Your Ref: OWPC14272
Our Ref: BR/133/17/HH 15-05-2017
Please ask for:
Richard Temple

Boundary fence
31 Frith Road Bognor Regis

PROPOSED BOUNDARY FENCE AT 31 FRITH ROAD, BOGNOR REGIS
FOR MR. & MRS. J. CIOK.

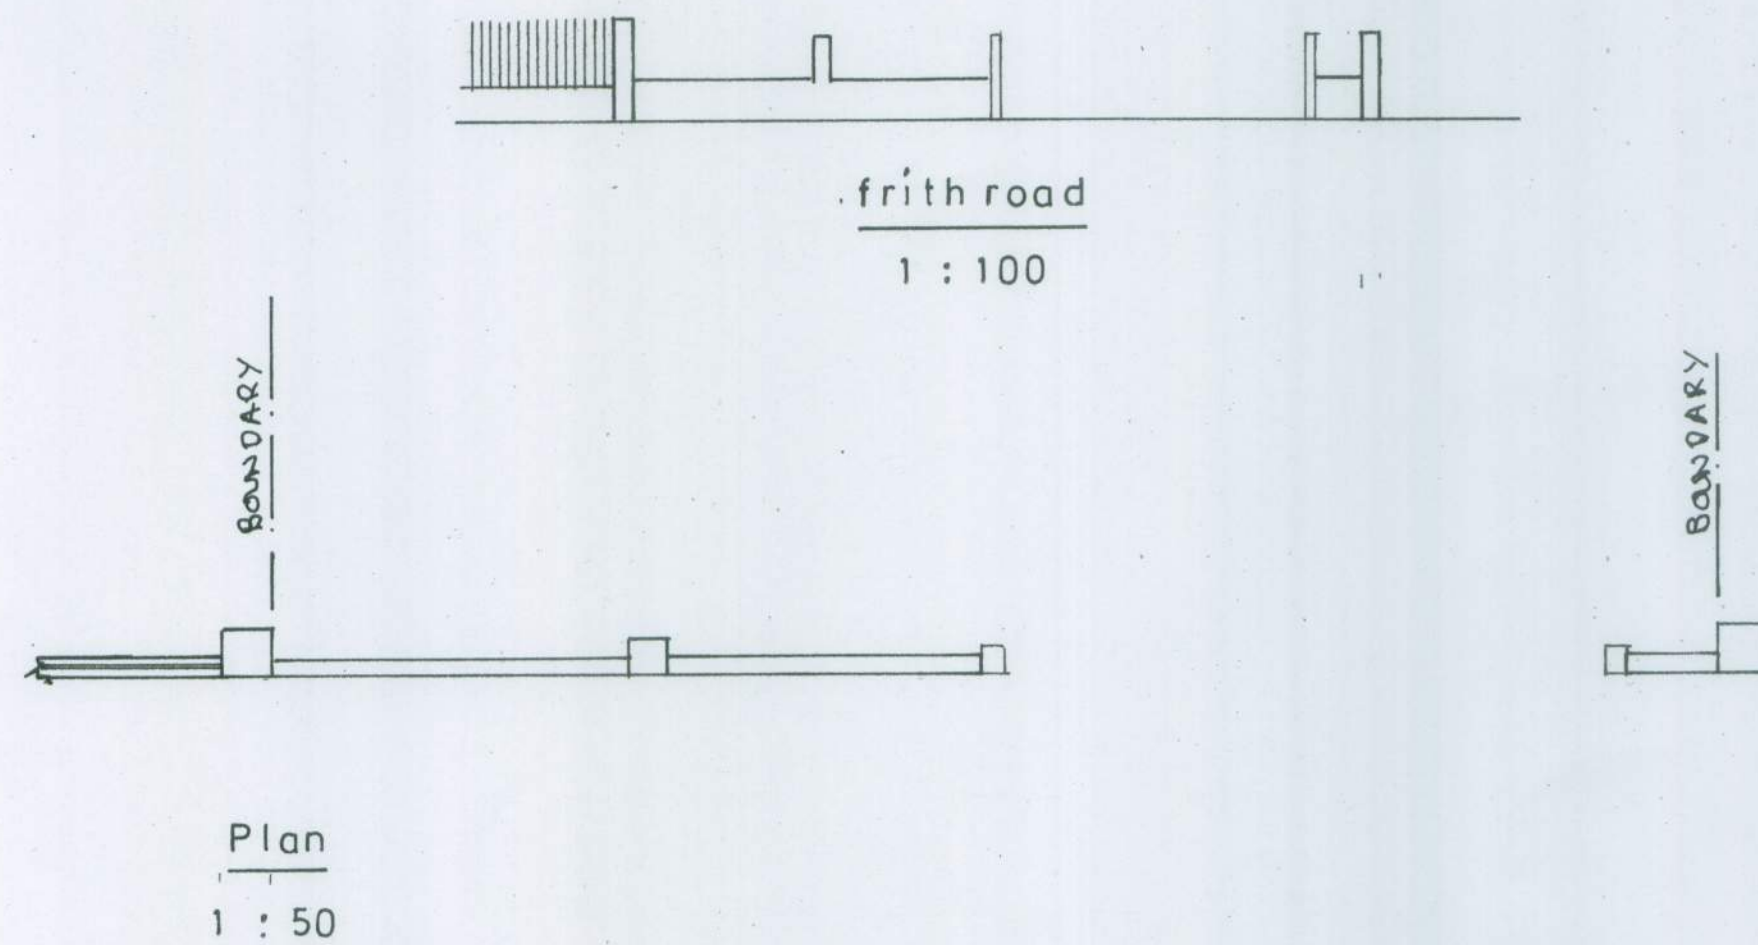
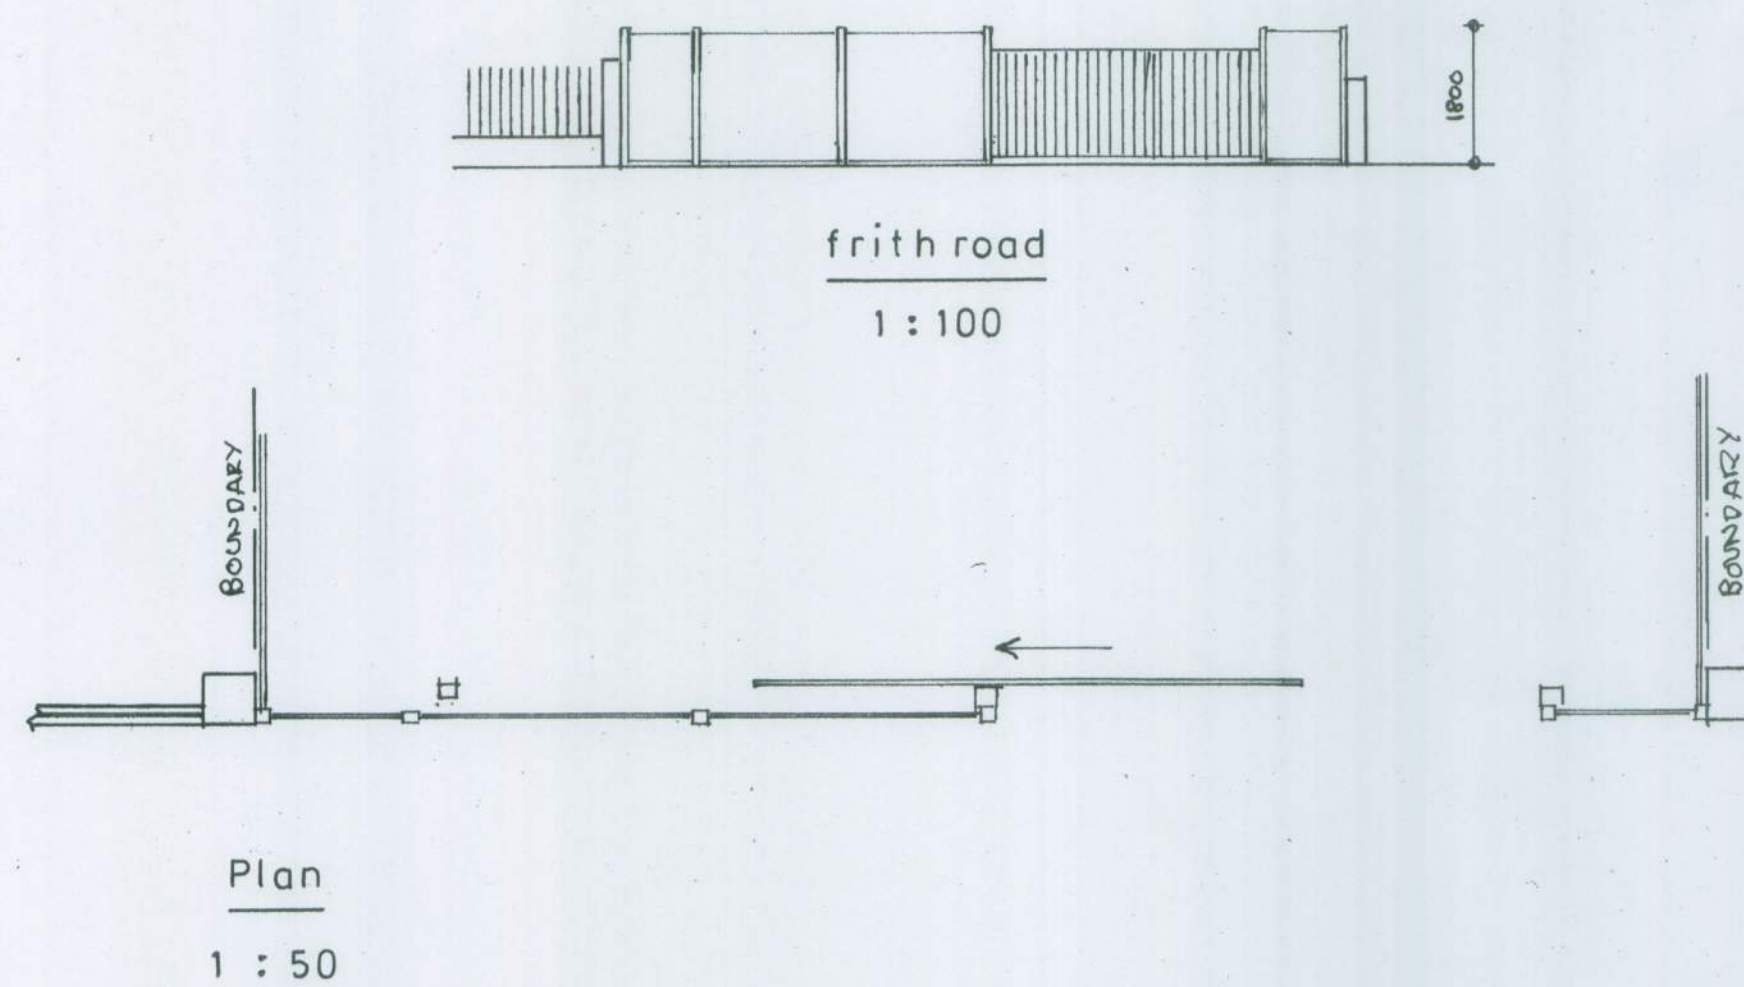
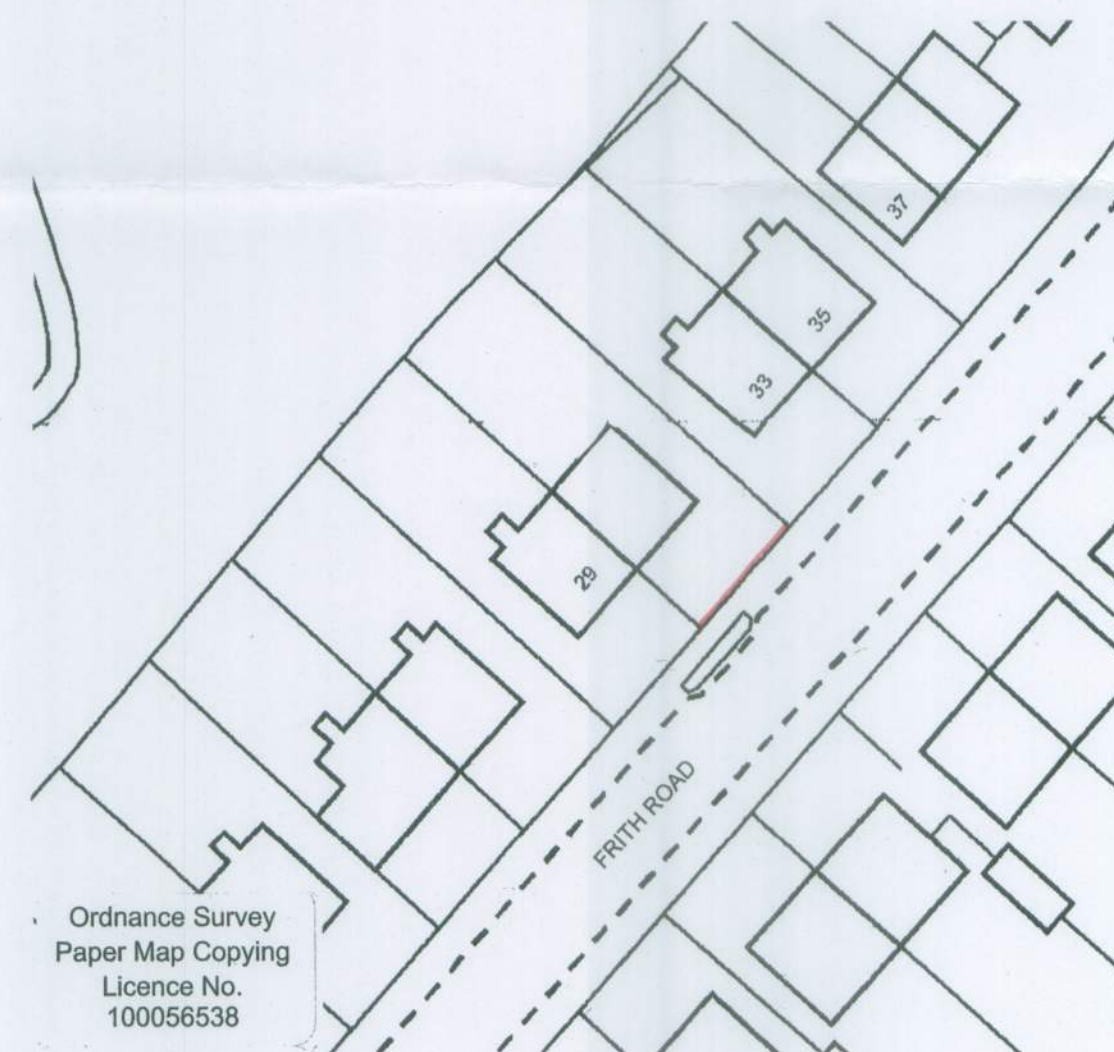
I would like more information regarding how the proposed changes to the boundary will affect the trees and planting along the boundary at the front of the house on my side of the boundary. It is unclear from the drawings. Number 29 is adjoined to 31.
